County of Bernalillo
State of New Mexico
Public Works Division

Subject: Bernalillo County Regional Recreation Complex (BCRRC), Mesa del Sol Traffic Impact Study

Below are Bernalillo County comments on the subject draft TIS dated April 18, 2022. Please address these comments for the subsequent submittal.

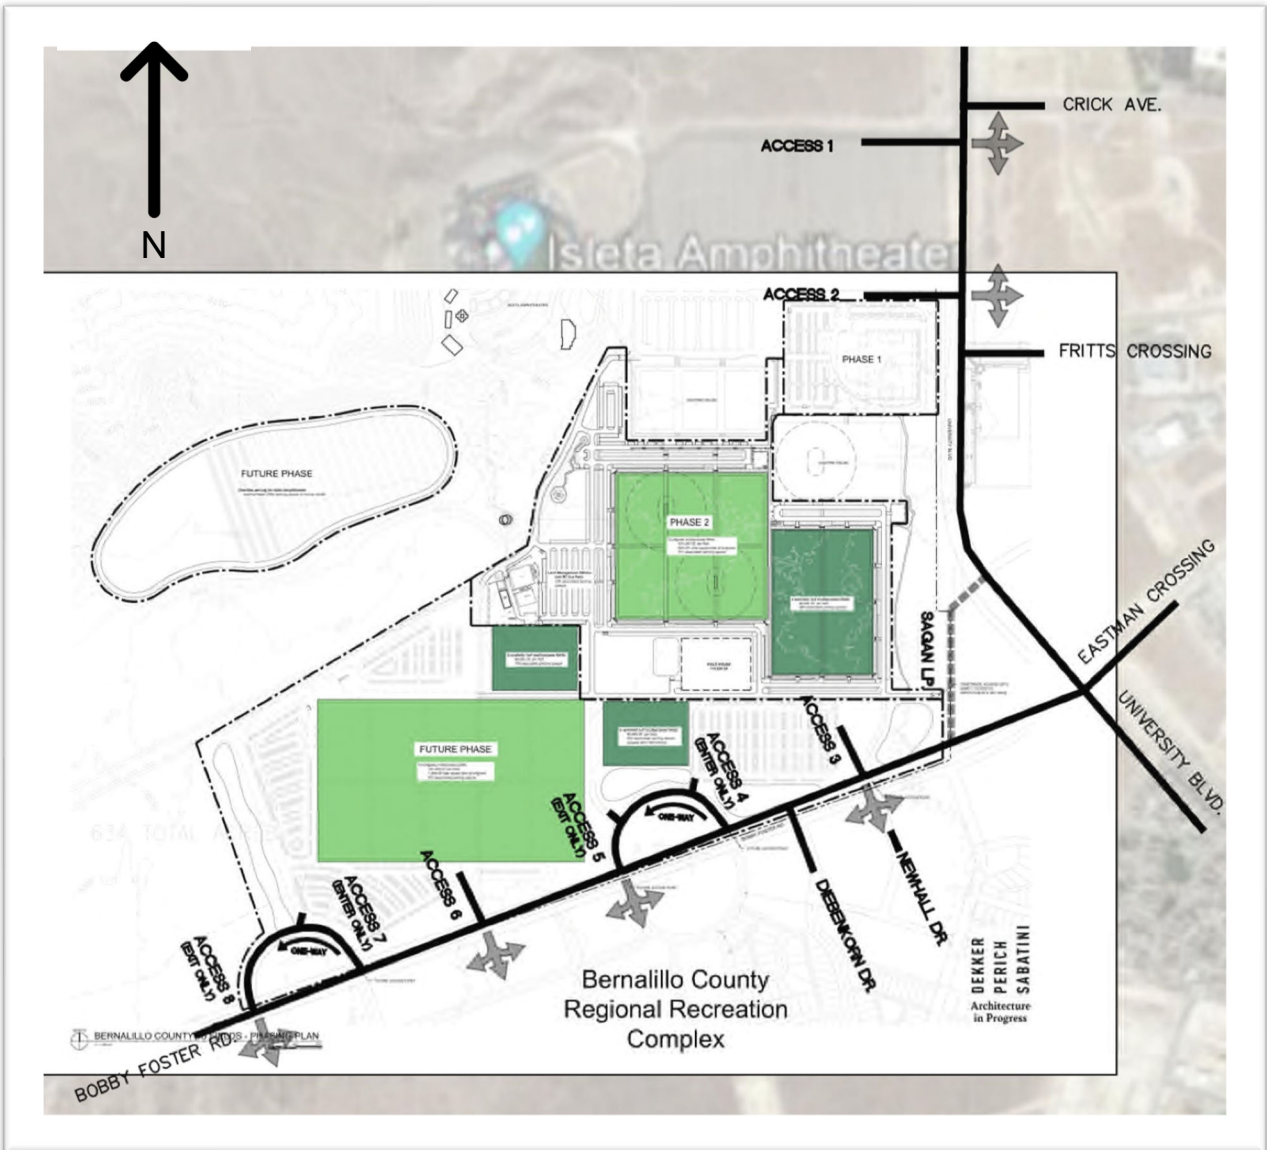
1. Page iv (Vicinity Map), Page 3, A-2 (Site Plan) – Please provide a legible image where the 1-3 phases and the associate generators (fields or offices) can be seen on the map. There is conflicting information on the site plan with symbology showing Access 5 & 8 as full access, but notes stating that each is either exit or enter only. The pages detailing each intersection provide images of this site plan with incorrect access arrows. These pages need to be updated as well.
